IKEA TEMPE

Town Planning Report

MP07_0149

Section 75W Modification of Mixed Use Bulky
Goods Retail (IKEA) and commercial
development at Princes Highway (former
Tempe Tip).

DRAWING
Master Floor Plan
Lower Ground Floor

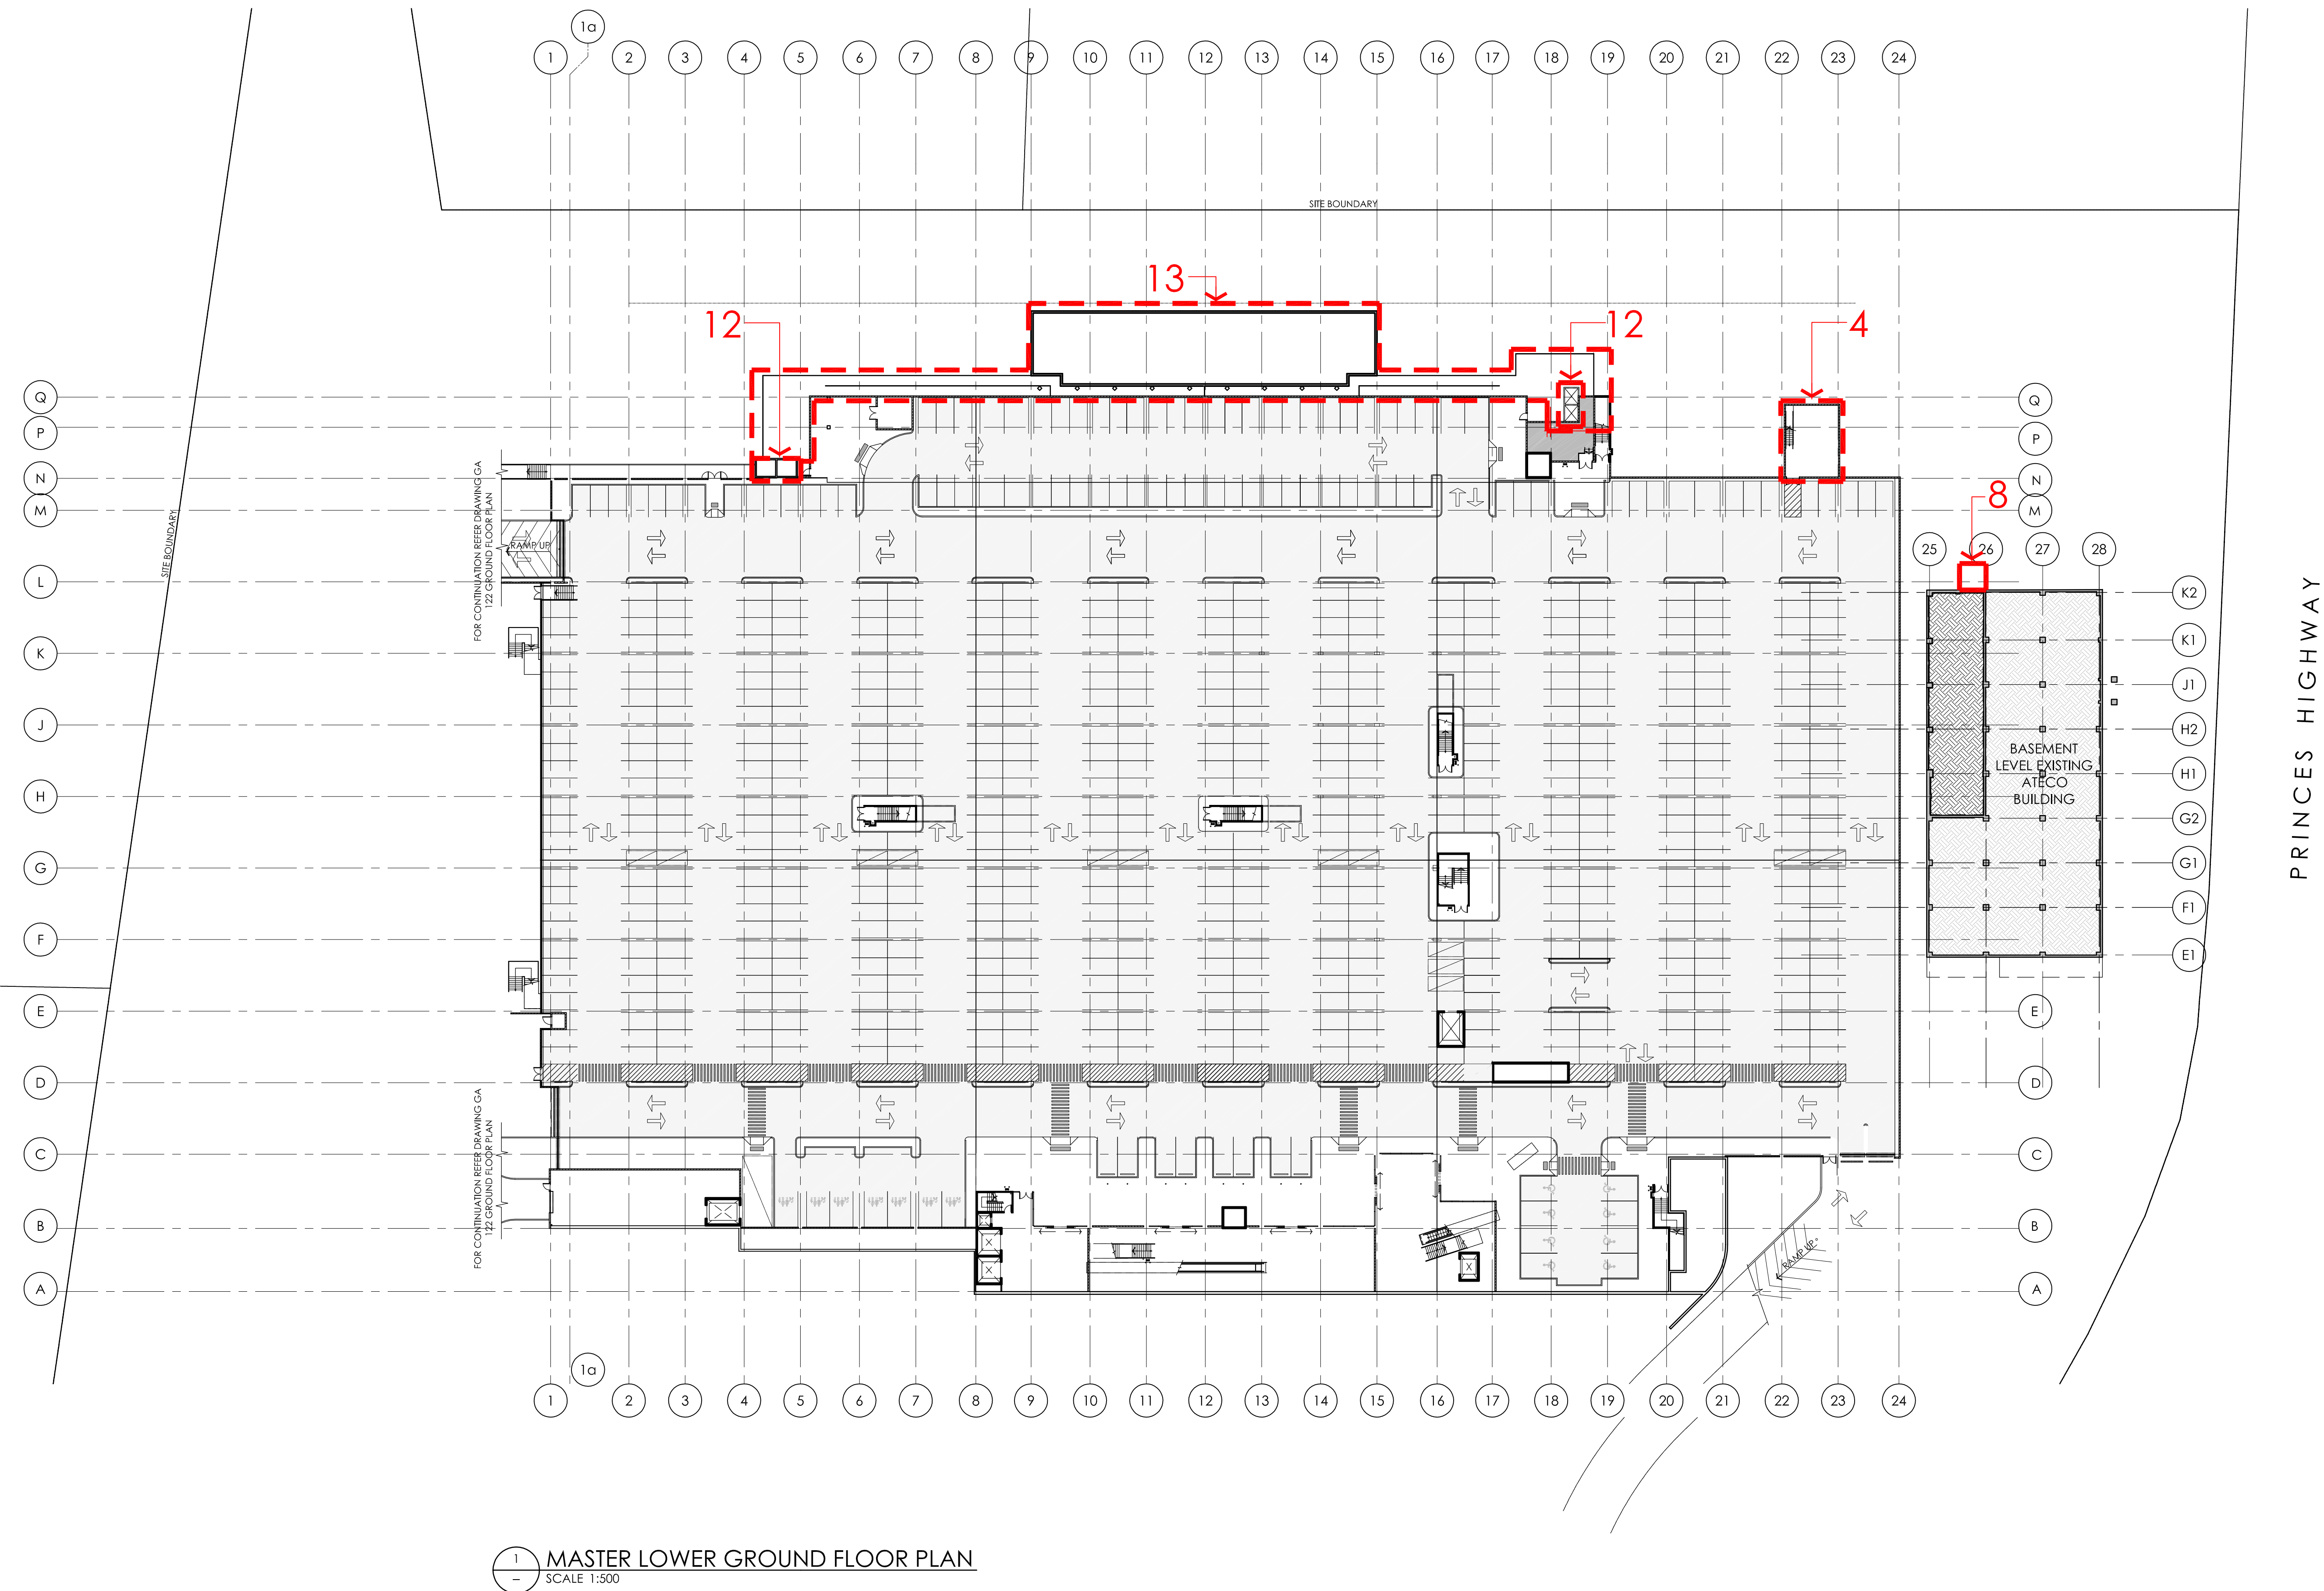
1. The deletion of the two balconies from the north elevation of the building.
2. Changes to the car park layout and entrance to the subject site.
3. Fire sprinkler tanks to be externally located.

4. Extension of the building for essential services area.
5. The deletion of the proposed glass canopy between the heritage building and the store.
6. Revised design of the canopy over the front entrance.

7. Change in the roof design.
8. Deletion of the lift at the southern end of the Ateco building.
9. The addition of the open mechanical platforms at roof level.

10. The addition of stair access up to roof level.
11. The relocation of the Fig Tree.
12. The addition of lower ground floor car park exhaust towers.
13. Addition of carpark exhaust plenum at lower ground level and drain water storage tanks under the loading dock slab.

14. Revised IKEA signage layout and dimensions
15. Addition of IKEA wordmark at roof level in roof membrane material.
16. Revised Landscaping Design
17. Addition of mechanical equipment in the lower ground floor of the ATECO Building.

18. Addition of louvers in the external wall of the first floor mechanical plant room.

- *Extension of the building for essential services at ground and lower ground level*

The proposal seeks a minor amendment to the building envelope at ground and lower ground level at the north eastern corner of the store. This additional area is sought for the purposes of housing essential services. It is not considered to result in an impact to the overall external appearance of the building and is considered to be a necessary modification to facilitate services.

DRAWING
Master Floor Plan -
Ground Floor

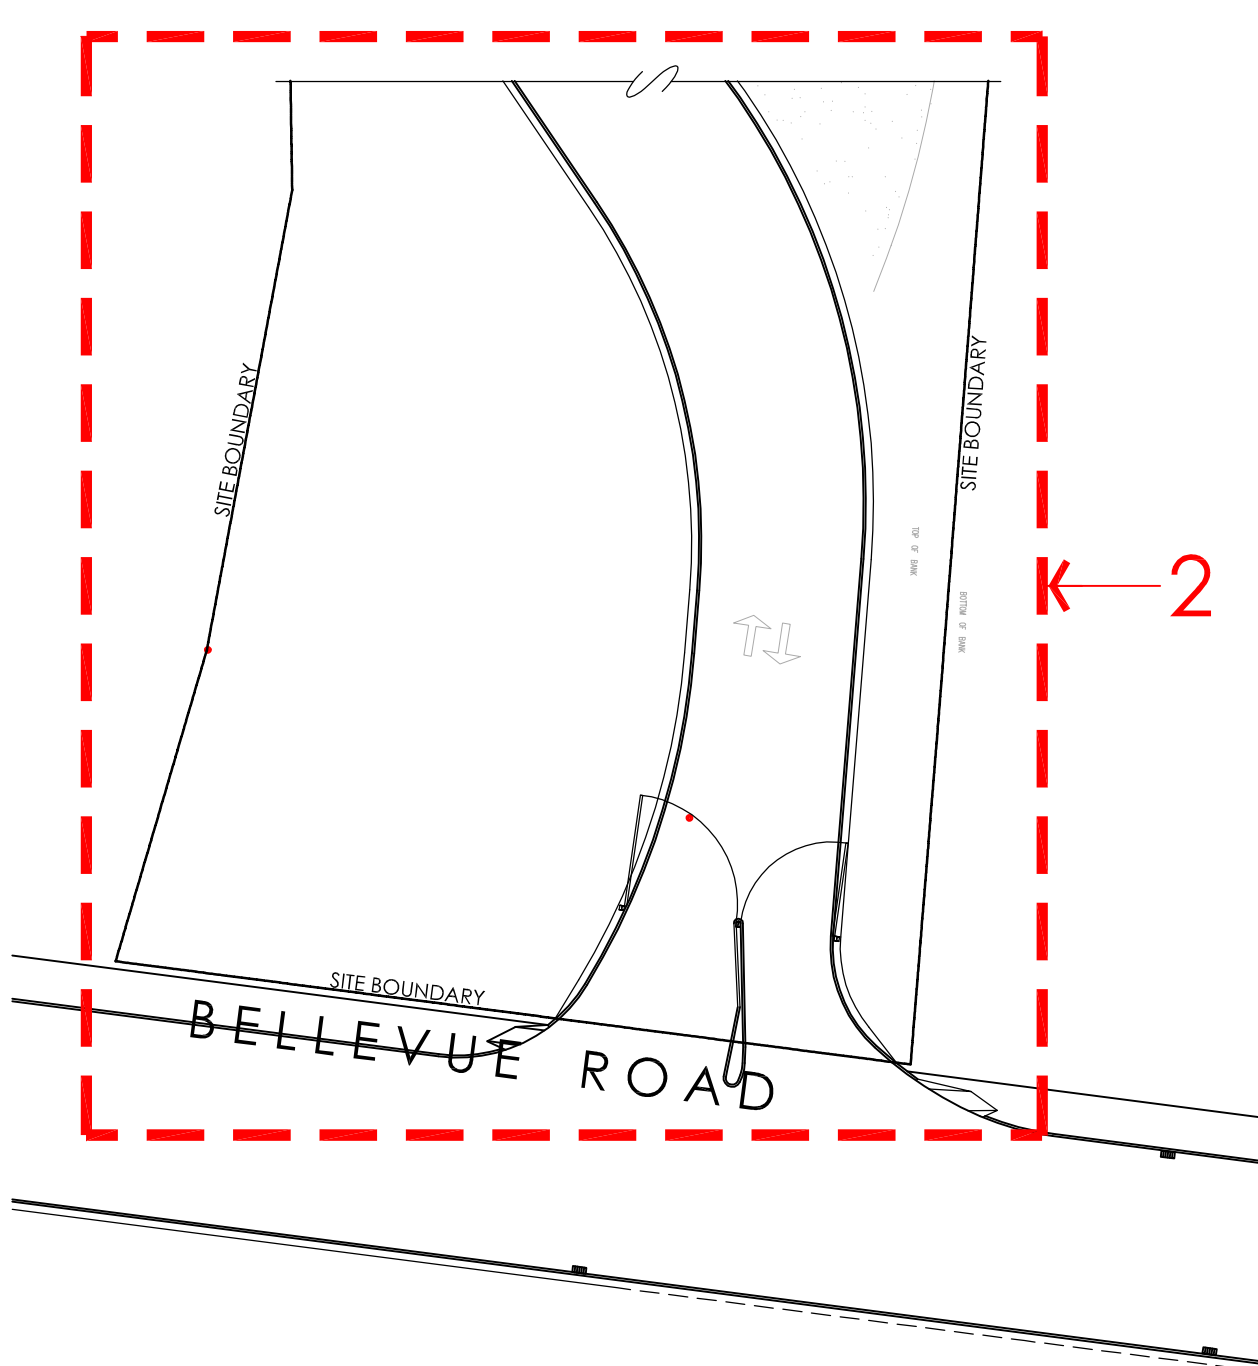
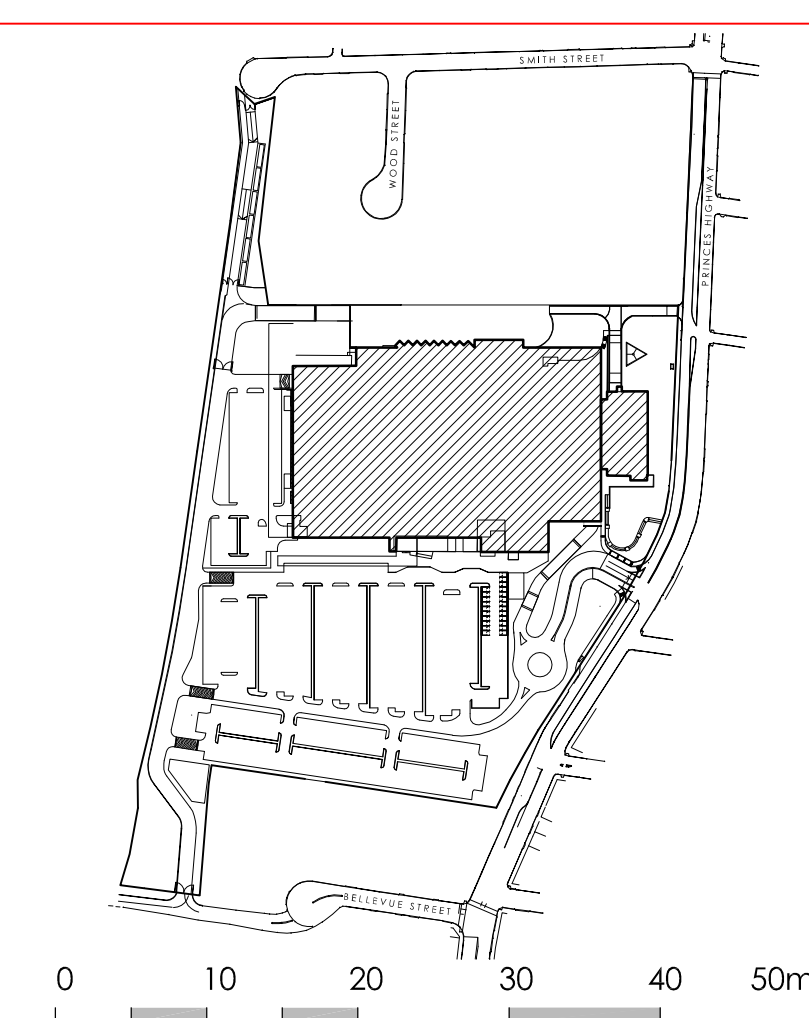
The proposal seeks to relocate the fire sprinkler tanks from the approved location next to the rain water tank further to the west of the southern elevation.

The previously approved location underneath the loading dock is considered to be inappropriate in terms of size for the fire sprinkler tanks. The proposed siting of the fire sprinkler tanks have been relocated following discussions with the fire brigade, and are now considered to be a more appropriate and accessible location. The proposed location will allow for improved gravity flow from the tanks.

The proposal seeks an amendment to the canopy over the front entrance to the store. This amendment will result in an improved external appearance for the entrance to the building. The revised design will improve the articulation of the building, providing a stronger presence at the northern elevation.
